RE- BE/130/14/HH
CASE OFFICER
Mrs J CHAPMAN
ARUN CIVIC CENTRE.
LITTLEHAMPTON.

Having now viewed the proposed building plans for 25A CENTRAL AVE submitted by HDA Projects Ltd for Mr + Mrs Collins I feel it would be foolish of me not to write and ask for clarification of intent re: ground floor extension rear of garage.

ground floor plan

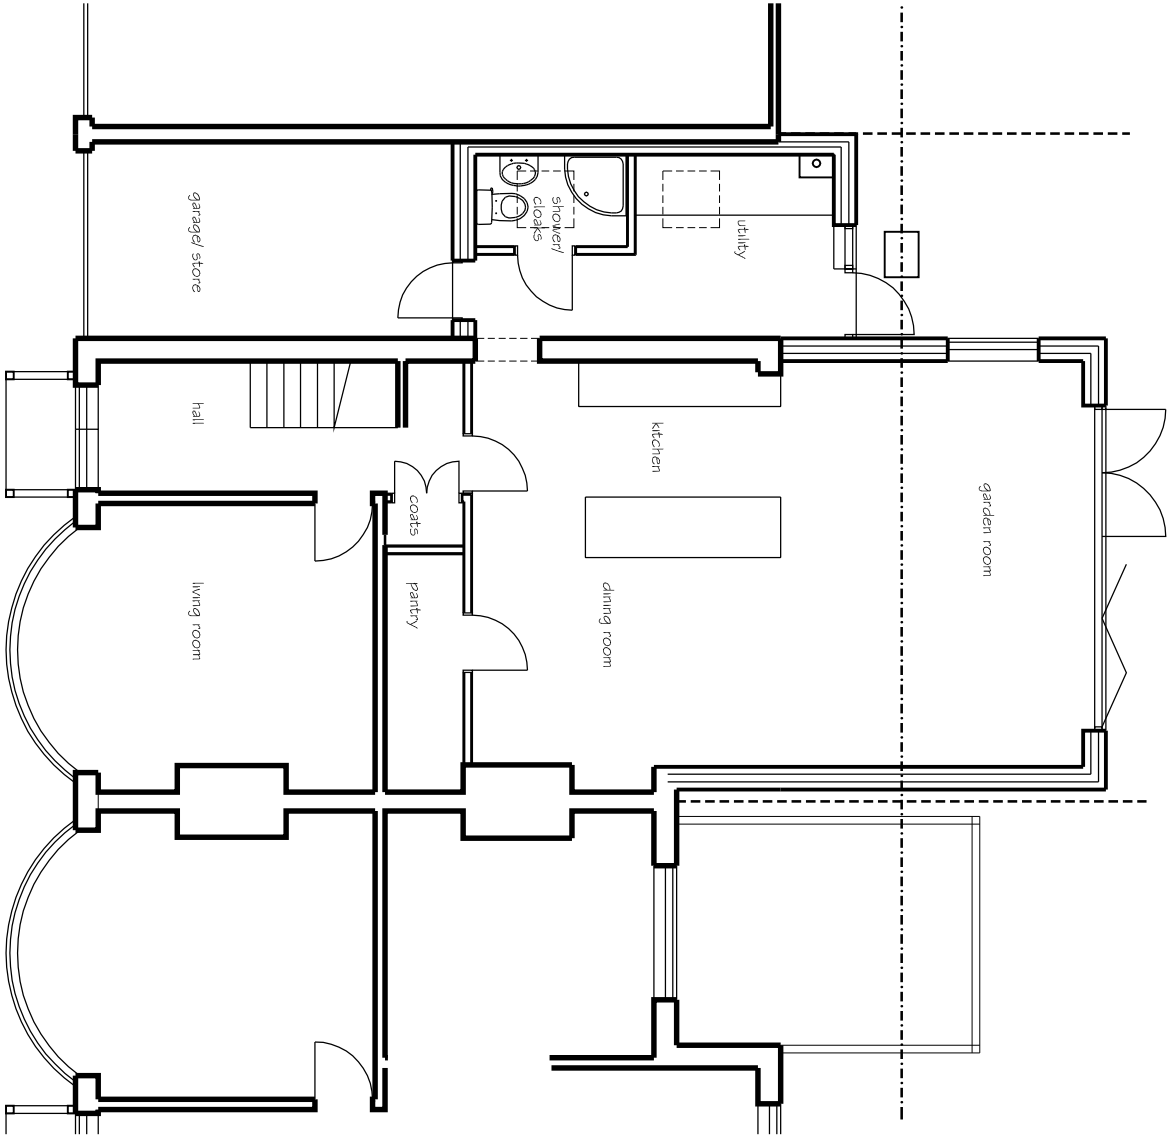
My concern and reason for asking for clarification of intent is that the builder appears to have used our (27) side of the party wall and gap between our two walls as his boundary line.

This is uncomfortable viewing because it leads one to believe that his intention is to use this single brick party wall to fix associated pipe work, electrics or even a stud wall to.

As this area is being proposed as a 3rd bathroom plus utility I feel it would not be unreasonable to ask that a sound-proofed solid brick wall should be built parallel to their side of the party wall. This would accommodate all associated pipe work, electrics fixture and fittings thus keeping the integrity and viability of the party wall intact and preventing any damage and associated unsociable bathroom noises.

As the proposed extension is also planned to be carried on into the garden this wall could then be used, thus avoiding any encroachment or disturbance to our land / property of which I also have concerns.
